Re: Project #PR-2019-002496 for Southeast Corner of Alameda Blvd. NE & Barstow Street NE

Vineyard Estates Neighborhood Association is aware of the upcoming [re]hearing for an application by Consensus Planning for a site plan on behalf of Philip Lindborg and the Mantoni

Family Trust for development of 93 apartments on the southeast corner of Barstow Street NE and Alameda Blvd. NE on August 14, 2019. It is our continued understanding that the property zoning is MX-L under the current IDO and this application is a permissive use of the property. Additionally, it

1 Site Plan - East
1" = 20'-0"

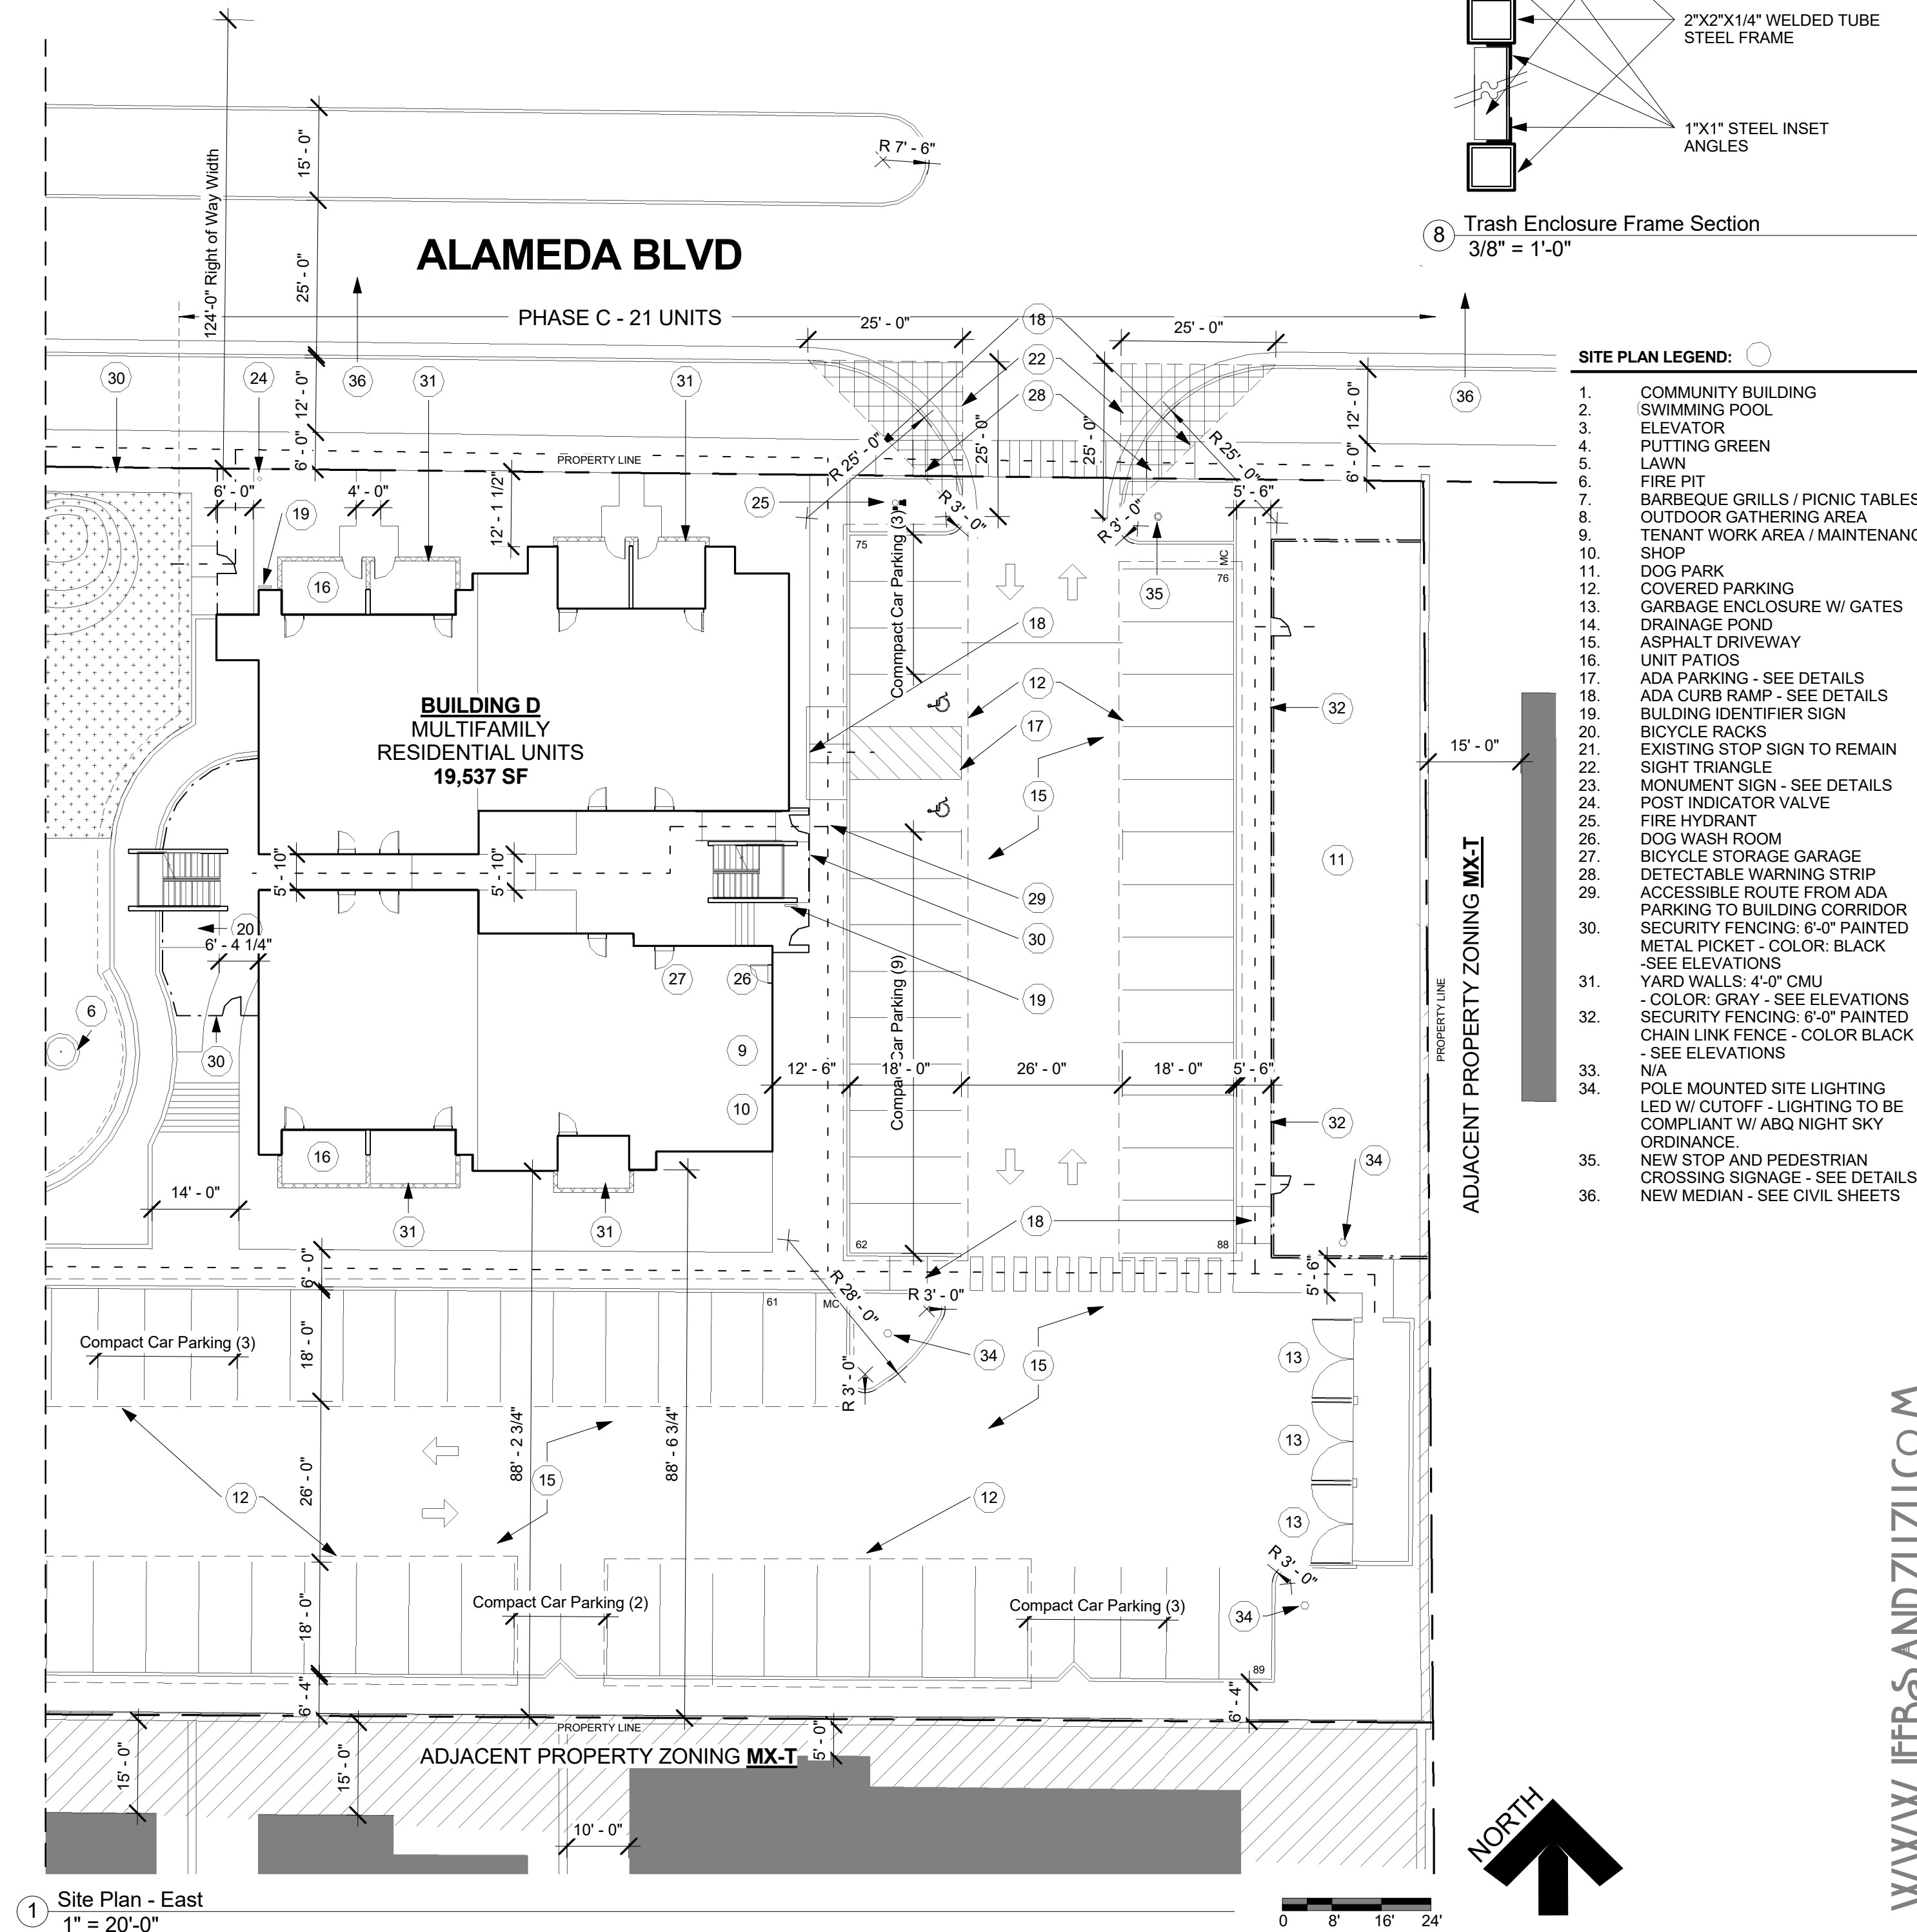
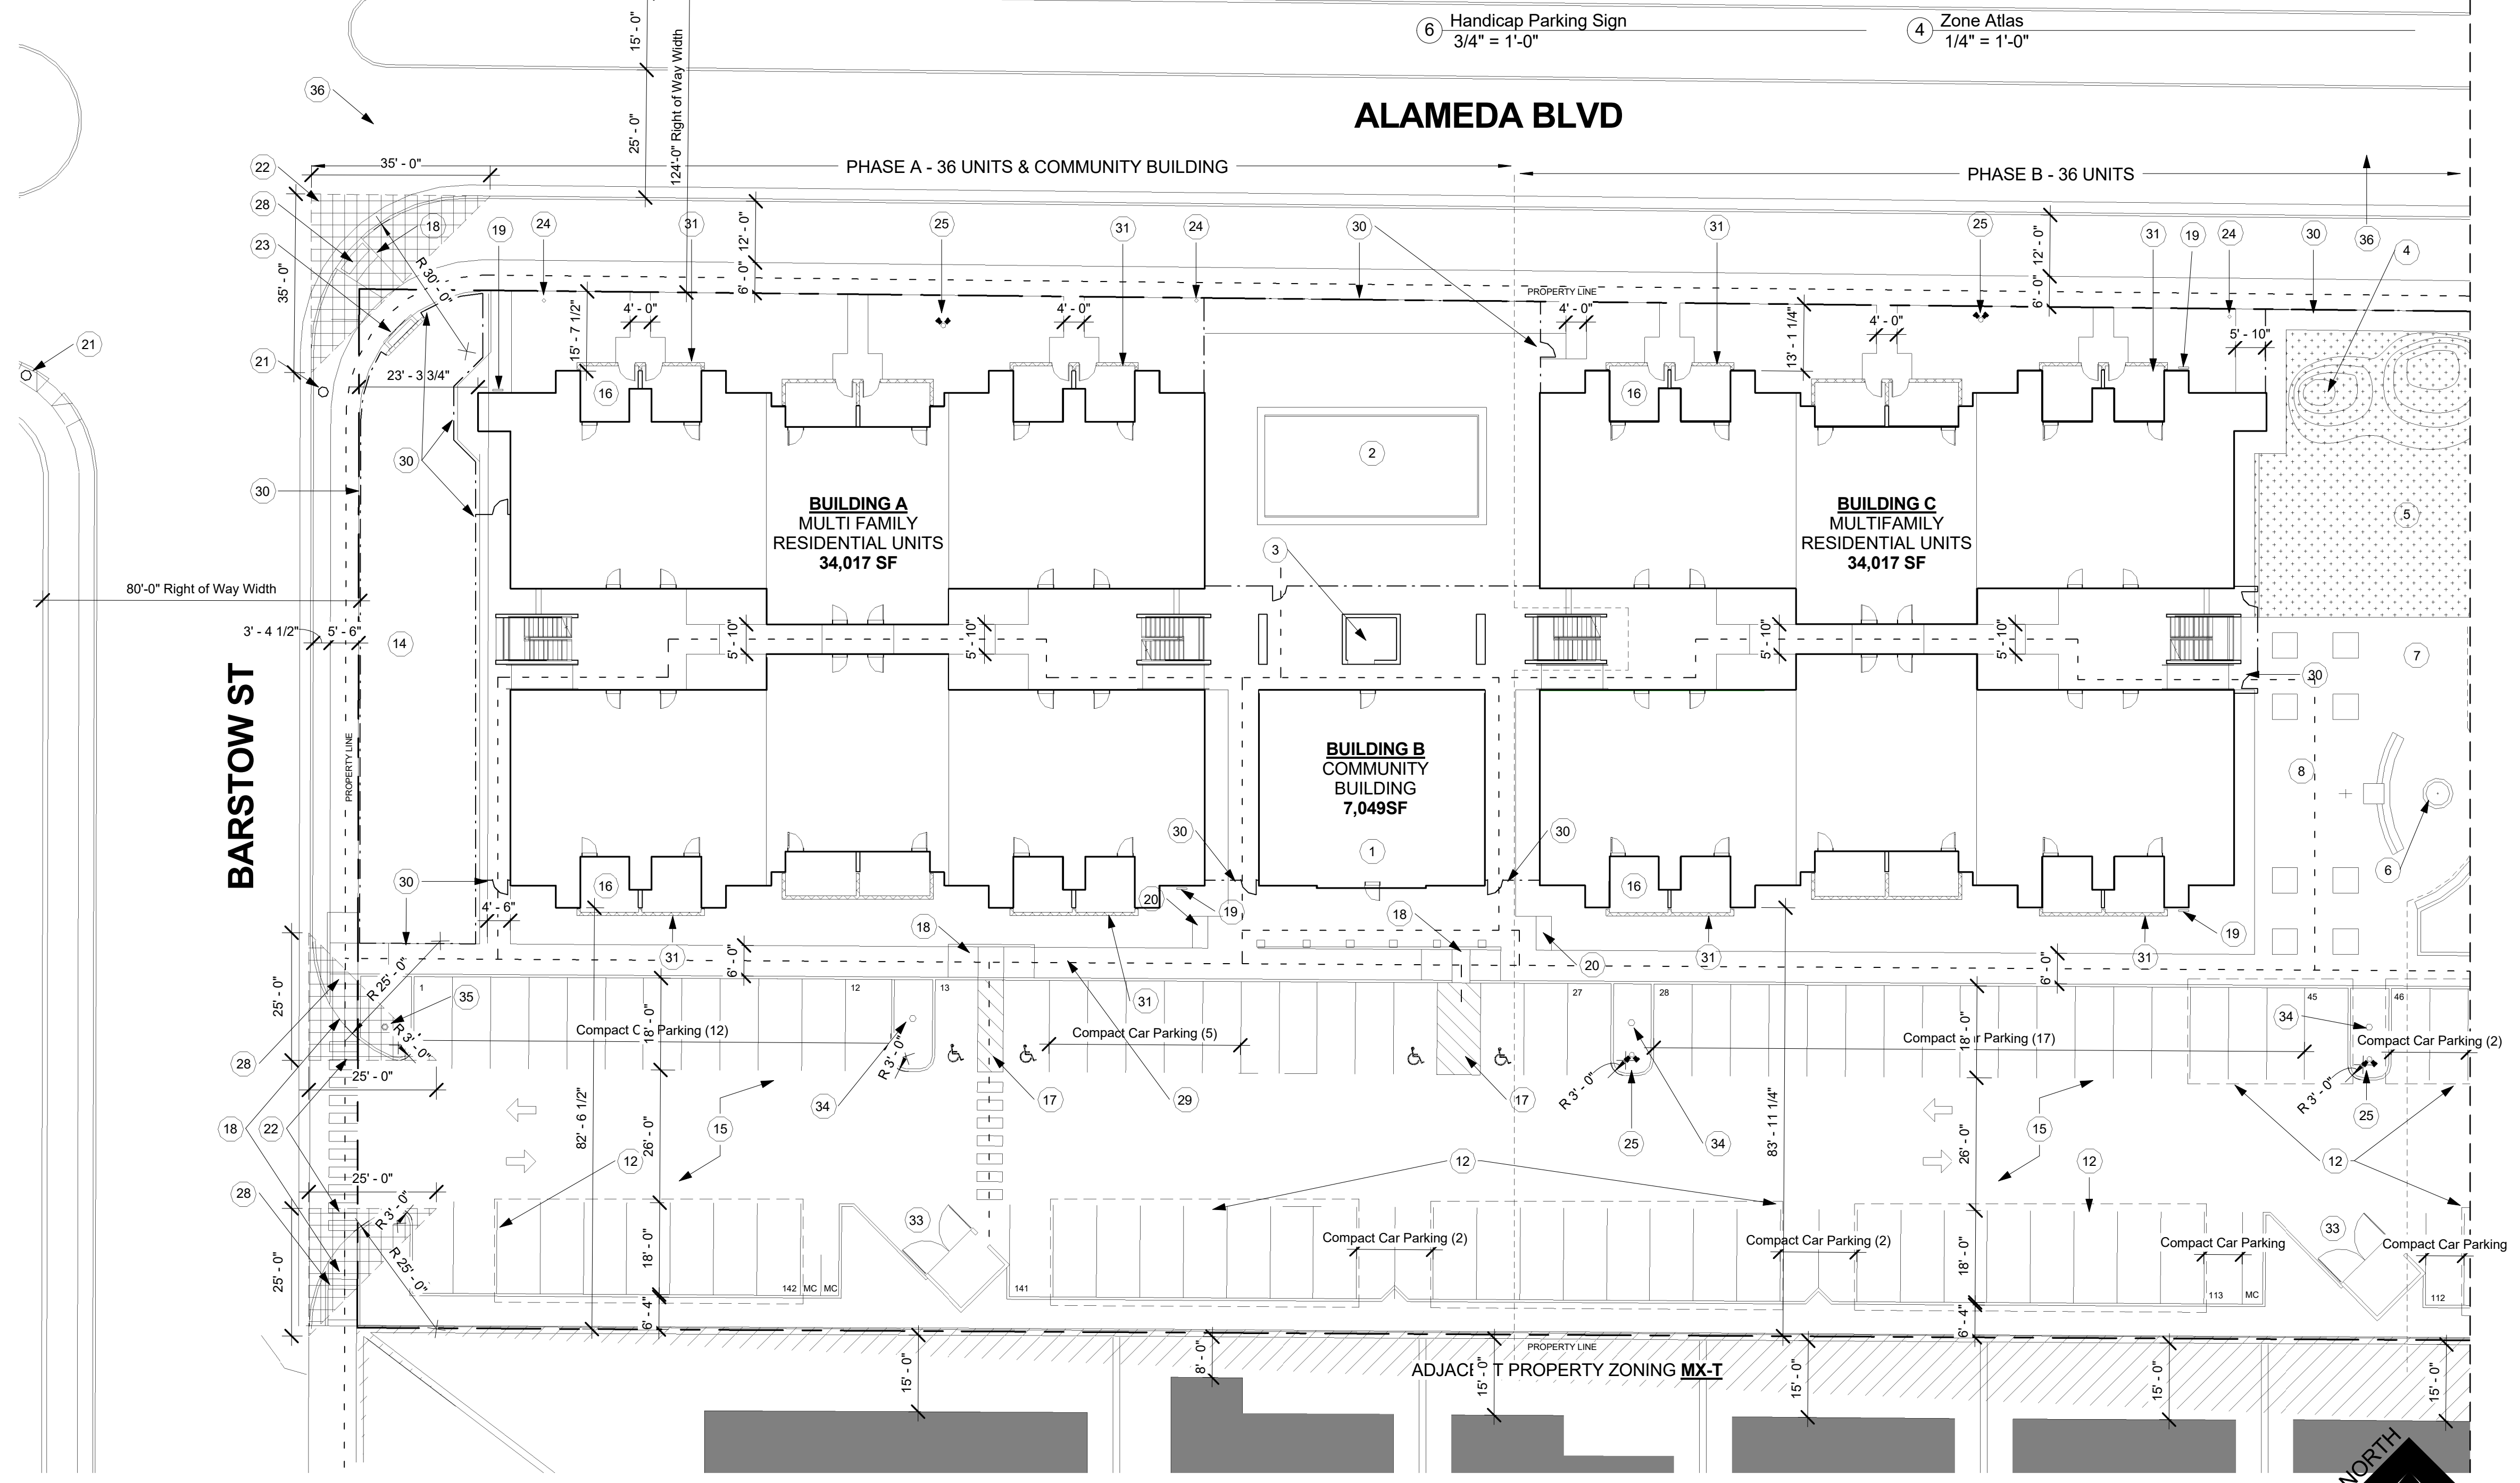
- 5) ***Dumpster and Garbage Location:*** While it is noted that the developer has tried to accommodate garbage and recycling locations to help reduce smell, noise, and nuisance, there will still be a problem to the Tierra Morena neighbors due to the proximity of these dumpsters to their rear properties. Garbage trucks feet from the south property owner's rear walls, as well as sour odors radiating from week old garbage make it difficult to see how this accommodation solves this problem for the very near neighbors.
